# ENG-PUDSP20005-R3-PUDSP-redlines.pdf Markup Summary

PUDSP-20-005

SITE PLAN NORTH

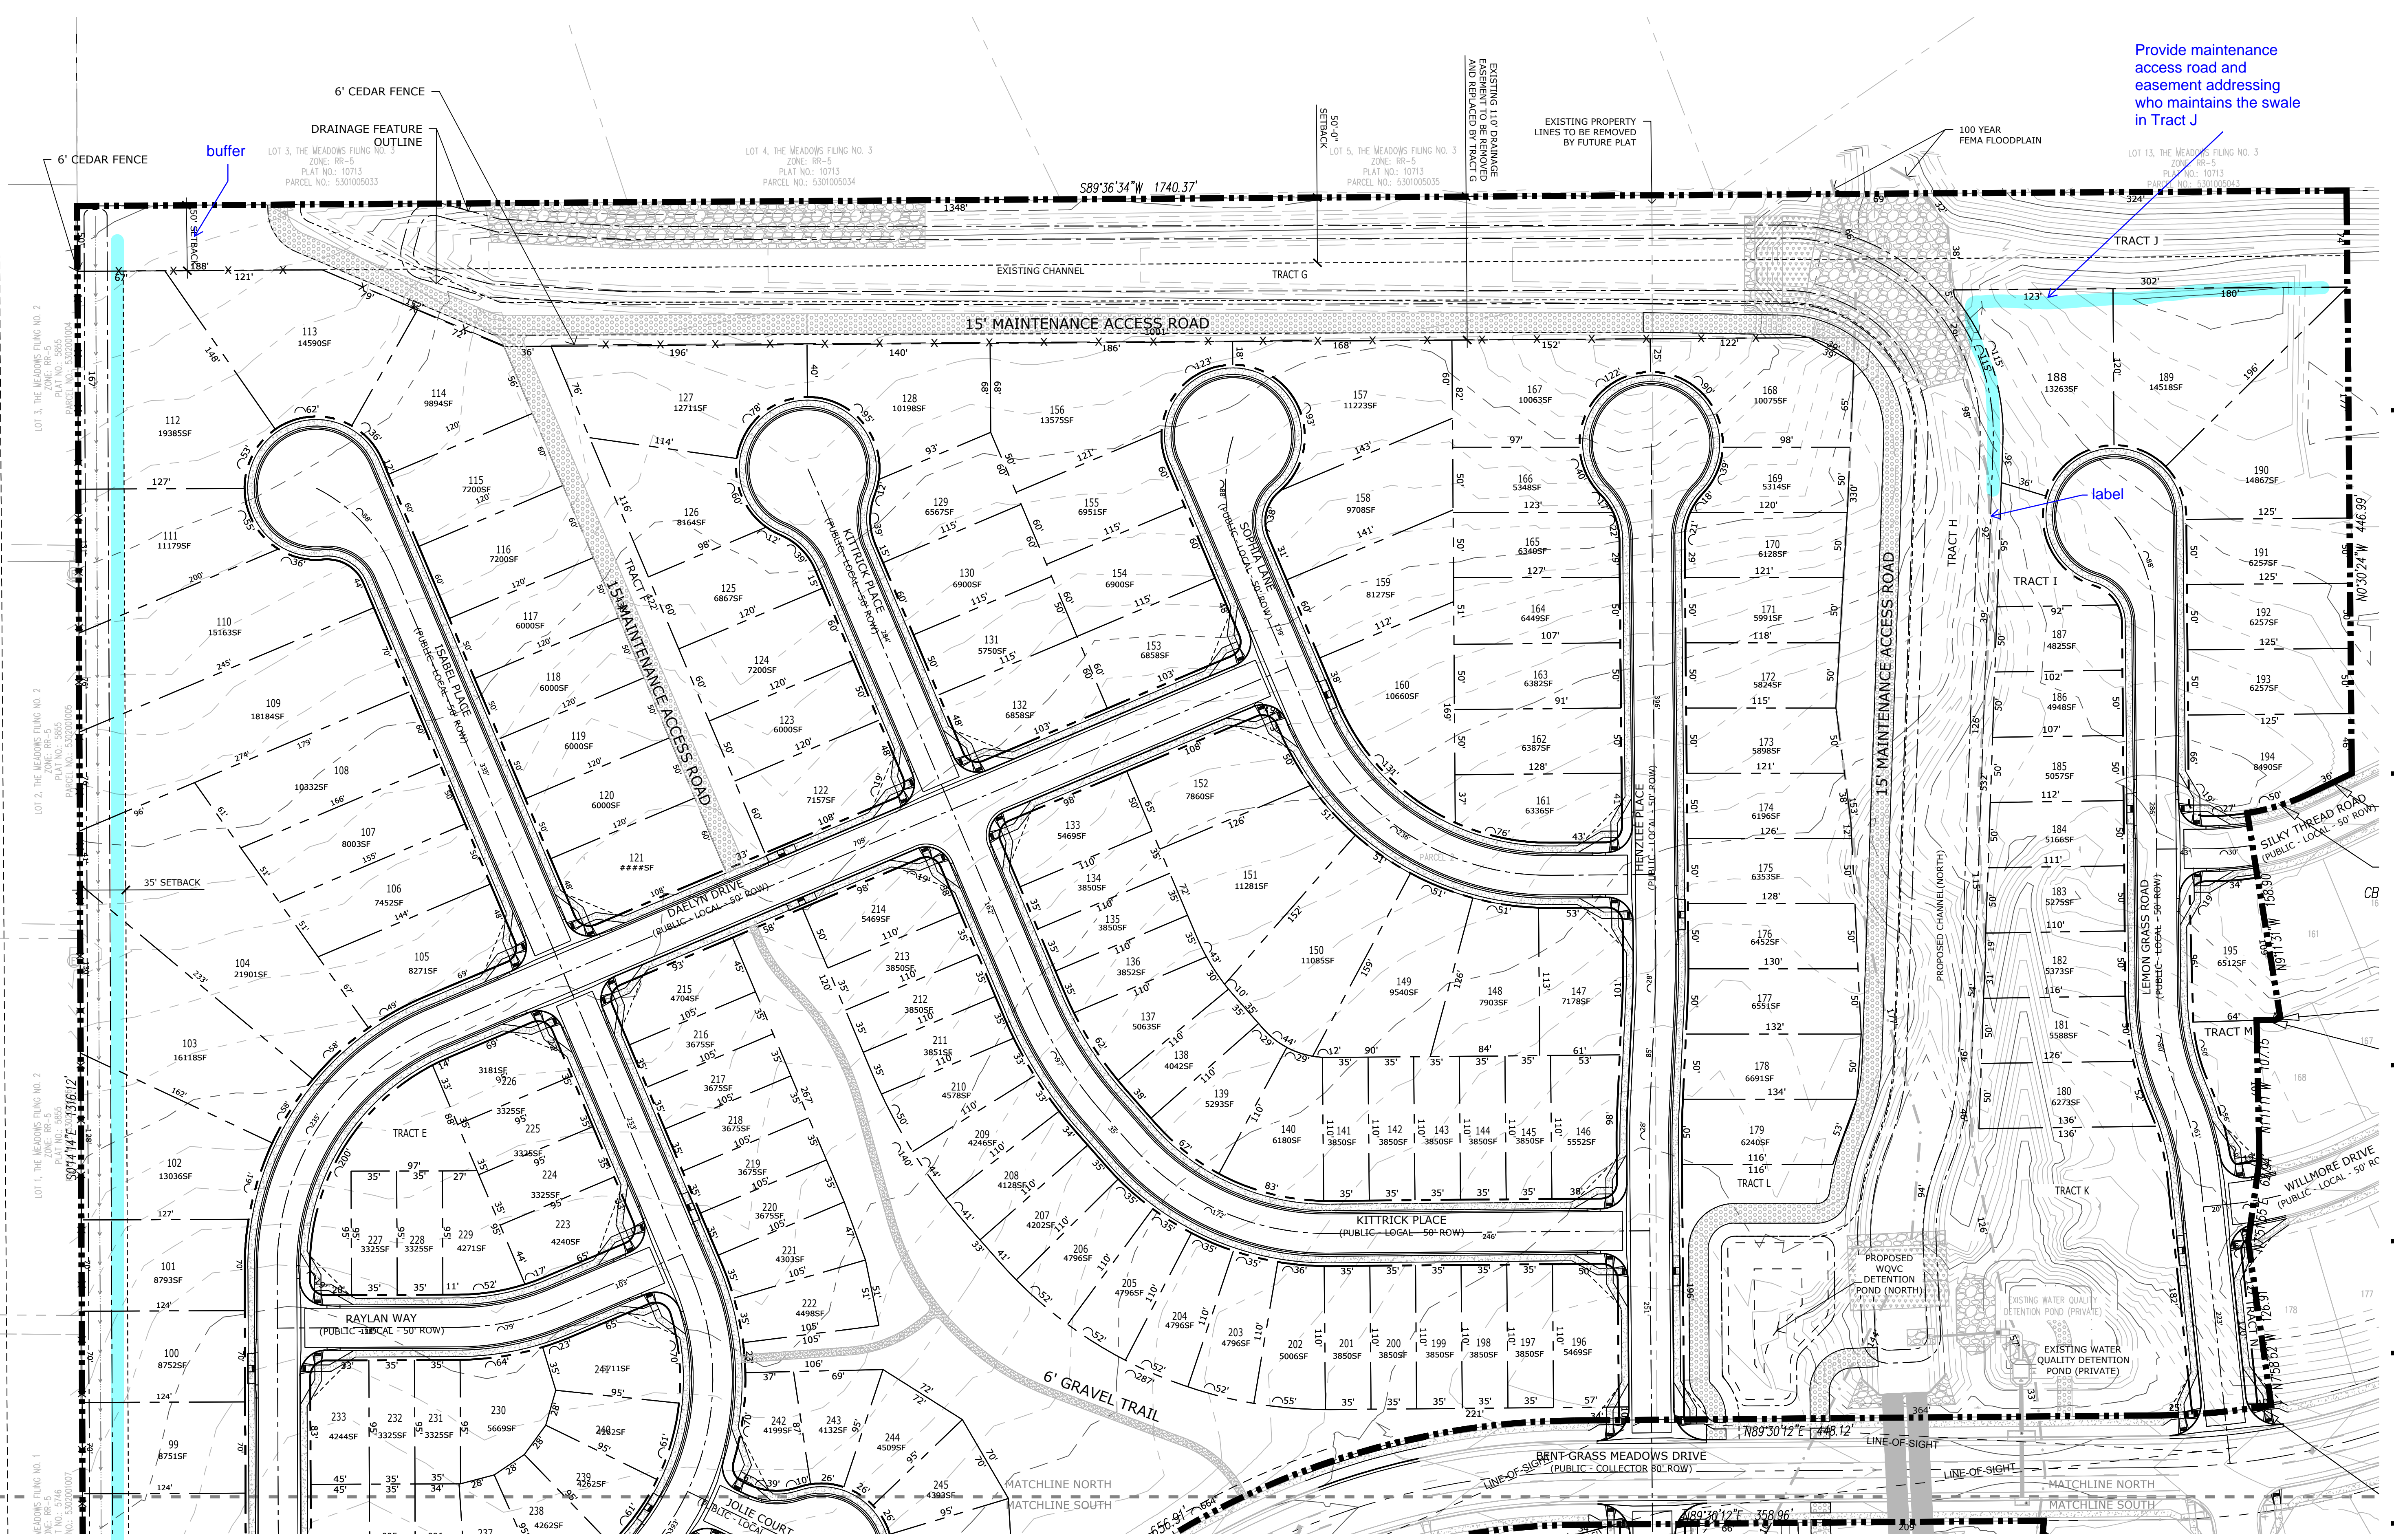
SETBACK

Buffer?

PRELIMINARY GRADING PLAN

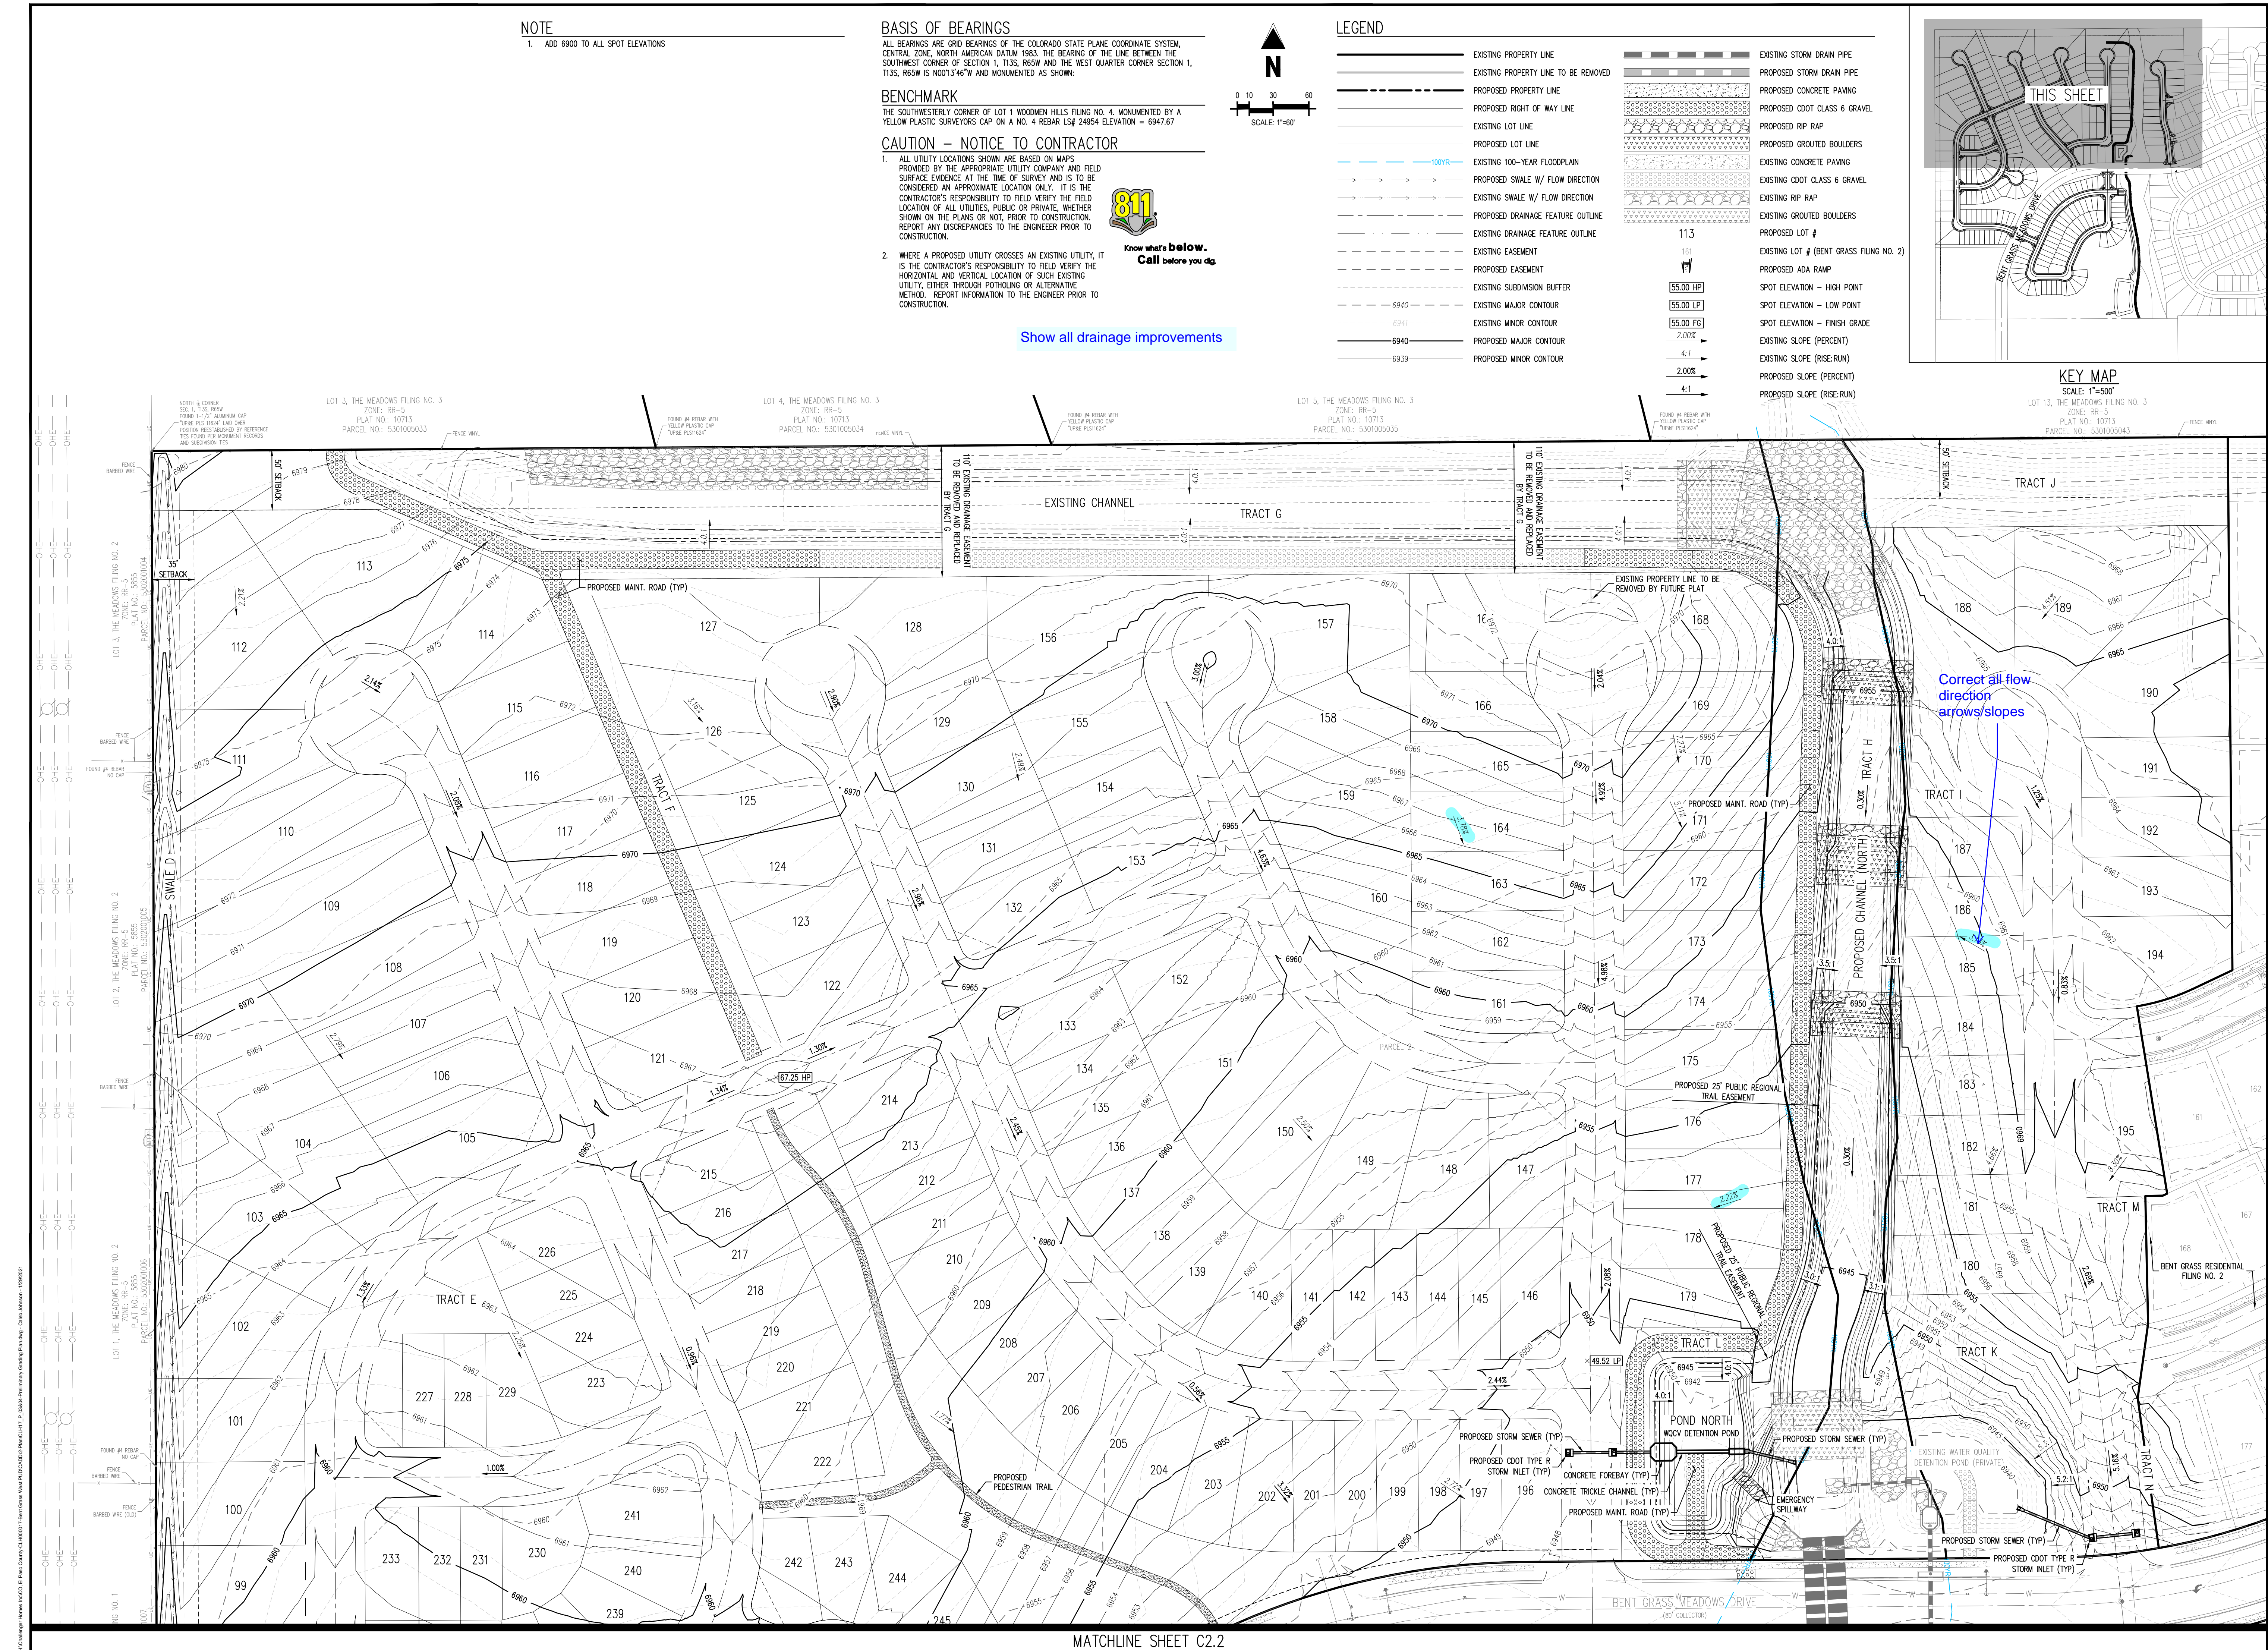
Show all curb and gutter

A swale is needed to convey flow to the WQ pond

KEY MAP
 SCALE: 1"=500'

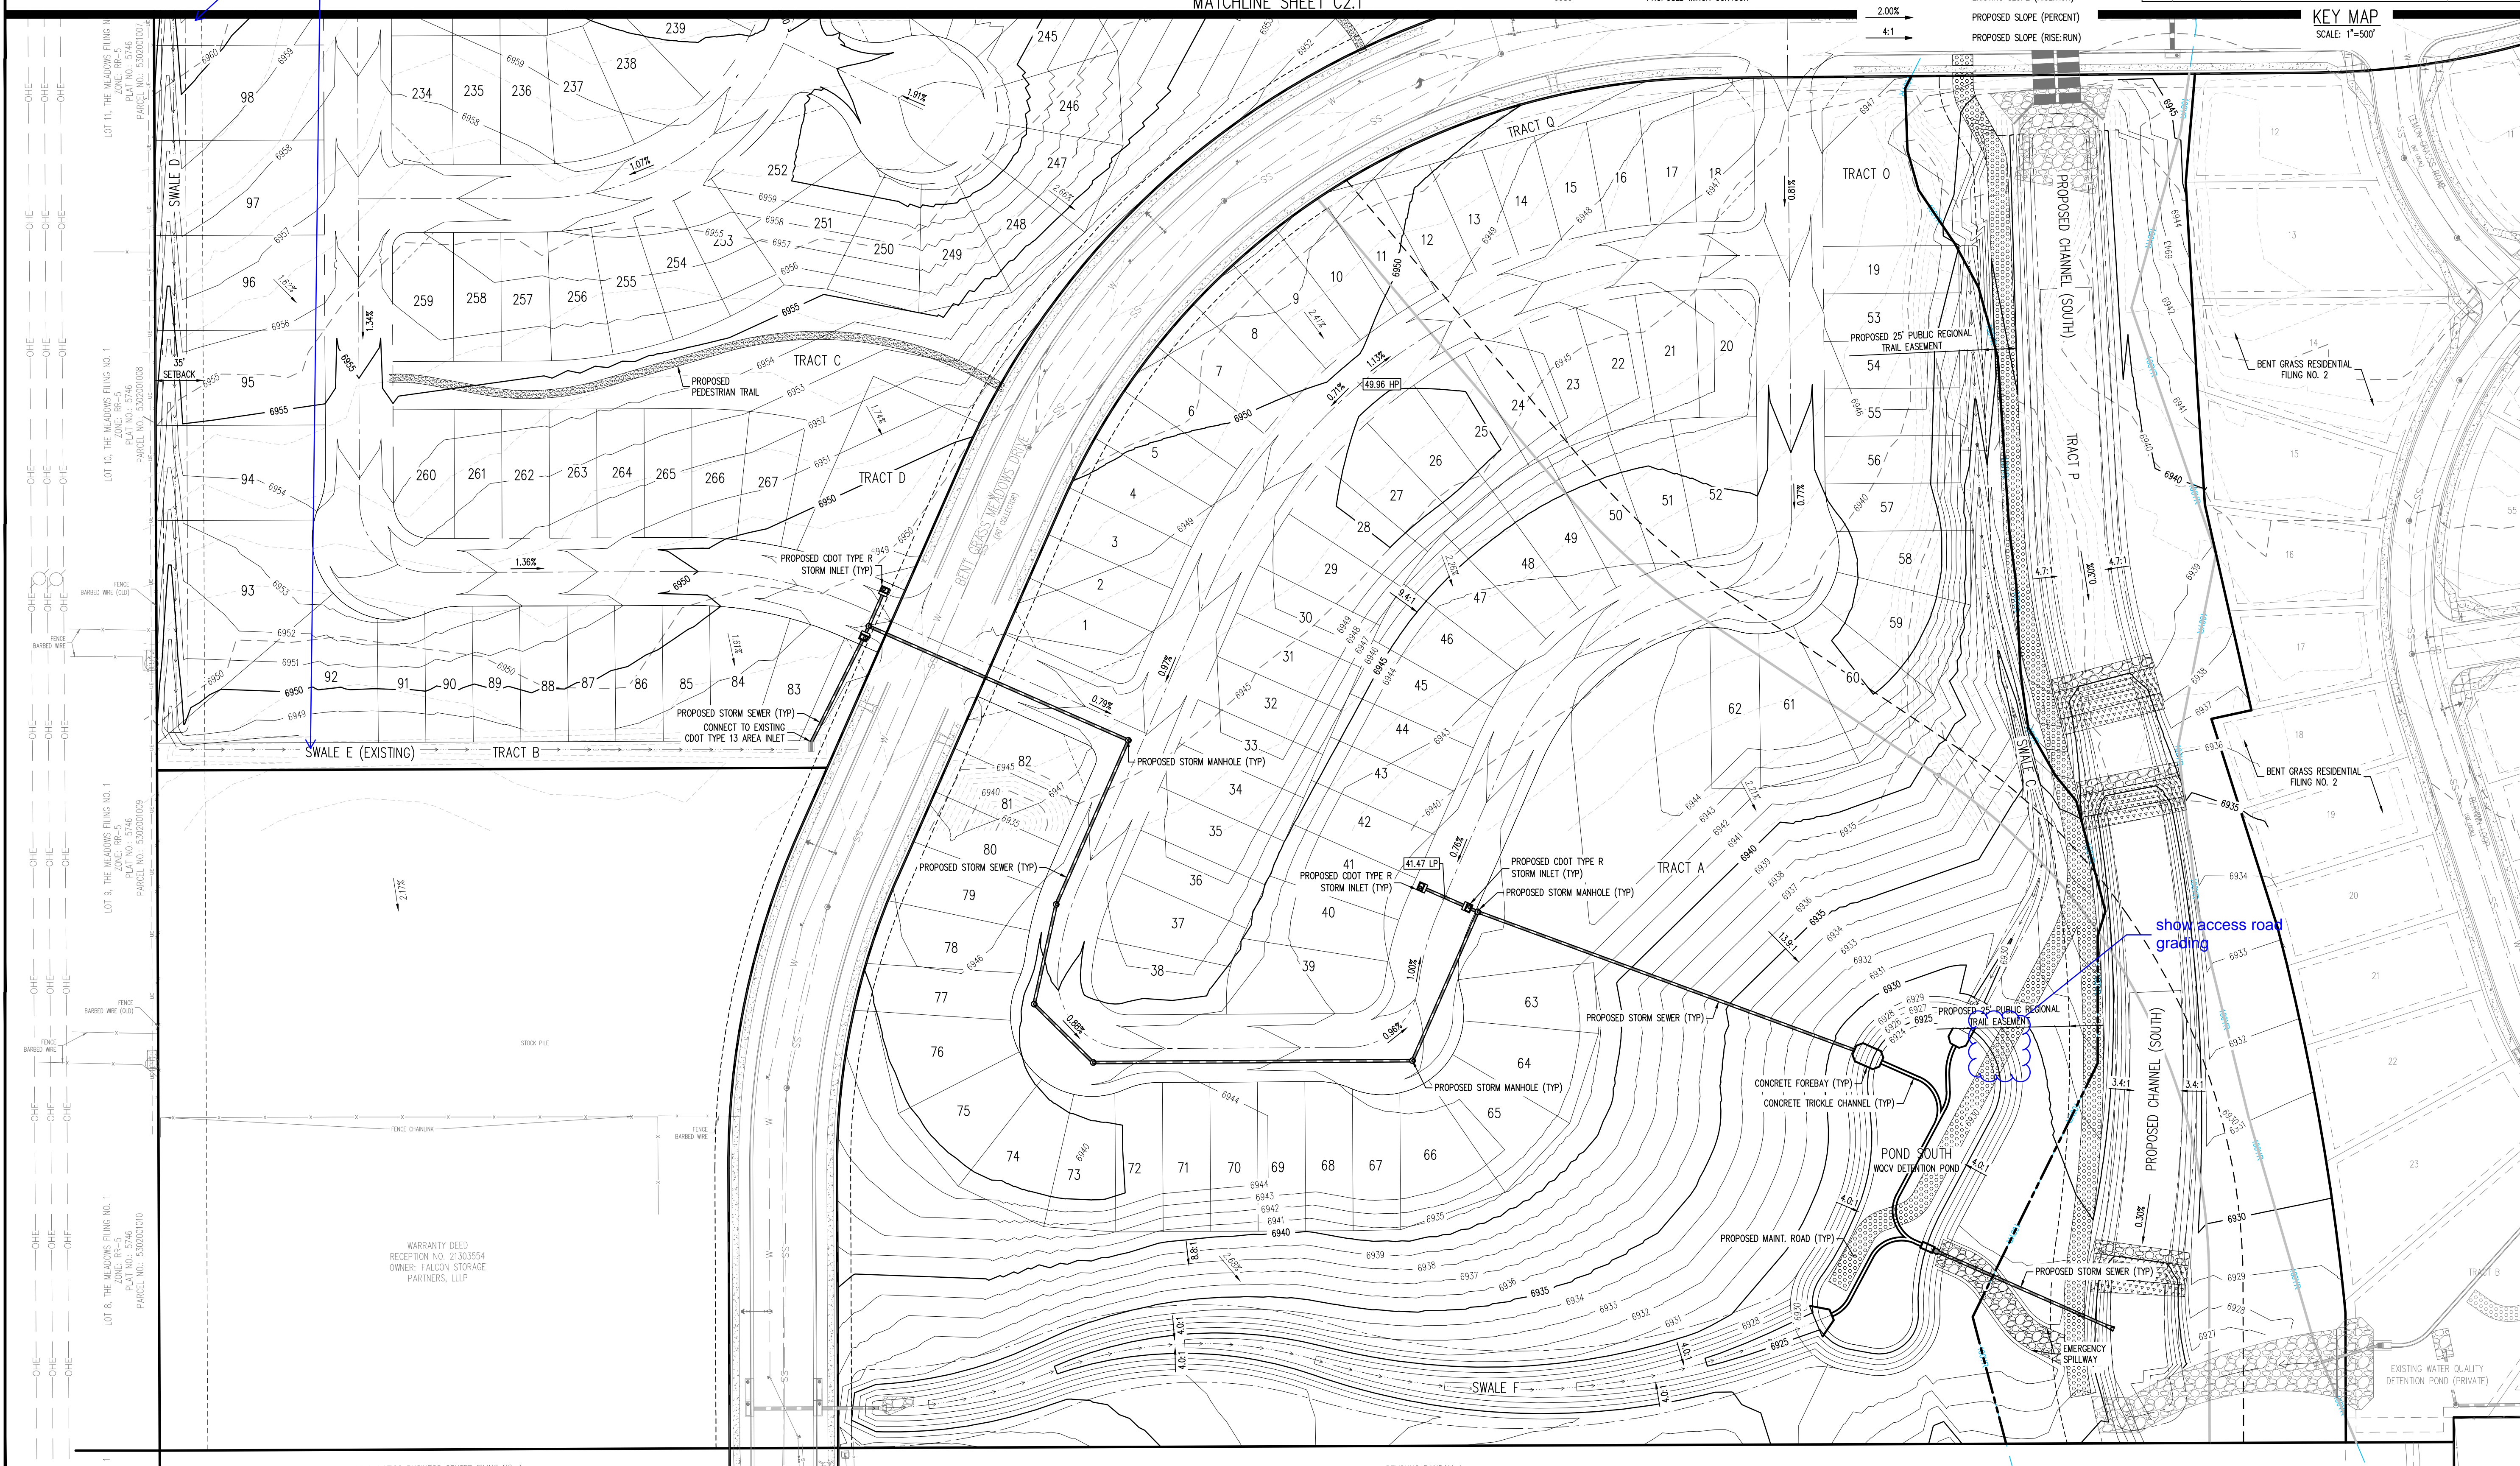
label the grade of the swales
